WEST SUSSEX COUNTY COUNCIL CONSULTATION

TO:	Arun District Council FAO: Mr. S. Davis
FROM:	WSCC – Highway Authority
DATE:	6 May 2025
LOCATION:	Land adjacent to Woodgate Nurseries Lidsey Road Aldingbourne PO20 3SU
SUBJECT:	<p>AL/143/24/RES</p> <p>Approval of reserved matters following outline consent AL/129/21/OUT for 95 No residential dwellings with associated parking, landscaping, open space (including play areas), infrastructure and works. This application is in CIL Zone 3 and is CIL Liable as new dwellings.</p> <p>Revised description & amended plans in response to feedback including a reduction in the scheme from 95 to 93 dwellings.</p> <p>Amended layout in response to WSCC Highways latest comments.</p>
DATE OF SITE VISIT:	n/a (visited at outline stage)
RECOMMENDATION:	Advice

This is the third WSCC Highways response to the above planning application seeking approval of reserved matters following outline consent AL/129/21/OUT for 95 No residential dwellings with associated parking, landscaping, open space (including play areas), infrastructure and works.

Title: Play and Open Space Proposals Sheet 1

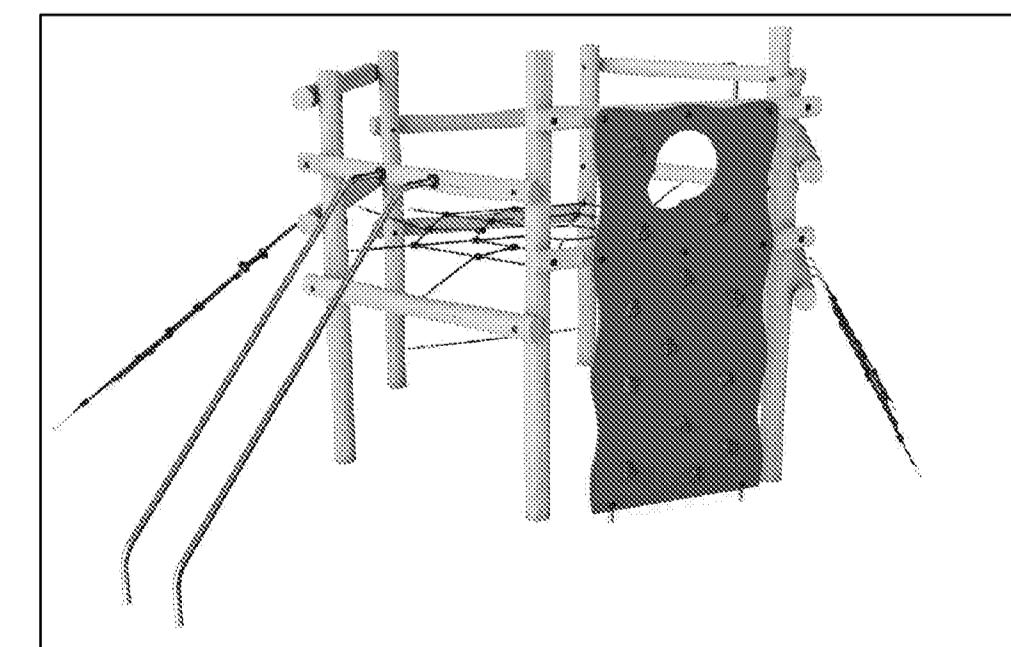
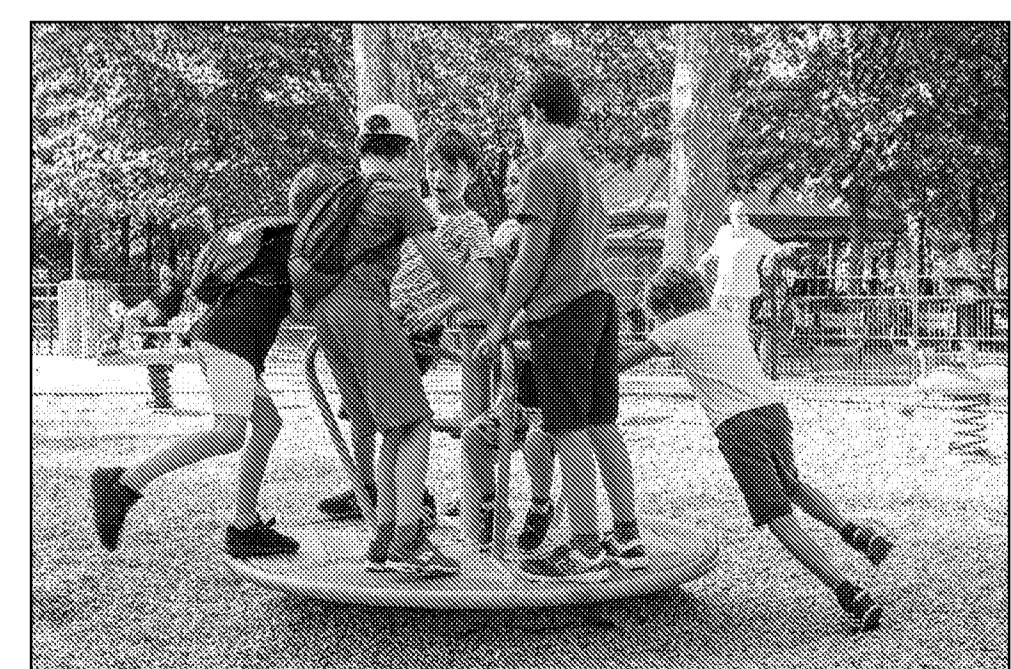
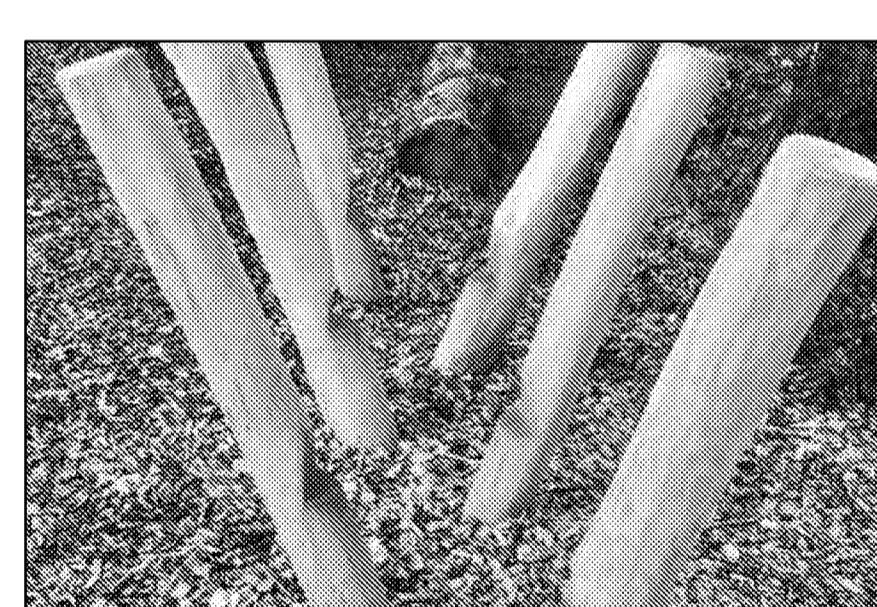
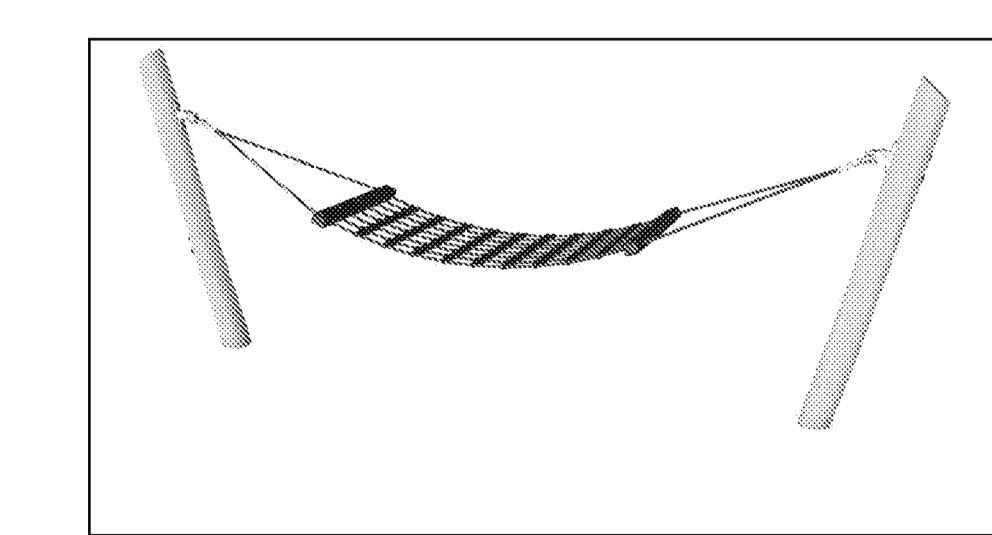
14. It is recommended that some external cycle storage (Sheffield Stands or similar) be provided throughout the layout, particularly adjacent to the LEAP and LAP. **Response still required.** **NOT SHOWN.**

Subject to confirmation that cycle stands will be implemented in or around the LEAP and LAP areas (see item 15 above), then the Highway Authority would be satisfied that all highway matters relating to this reserved matters application would be satisfied.
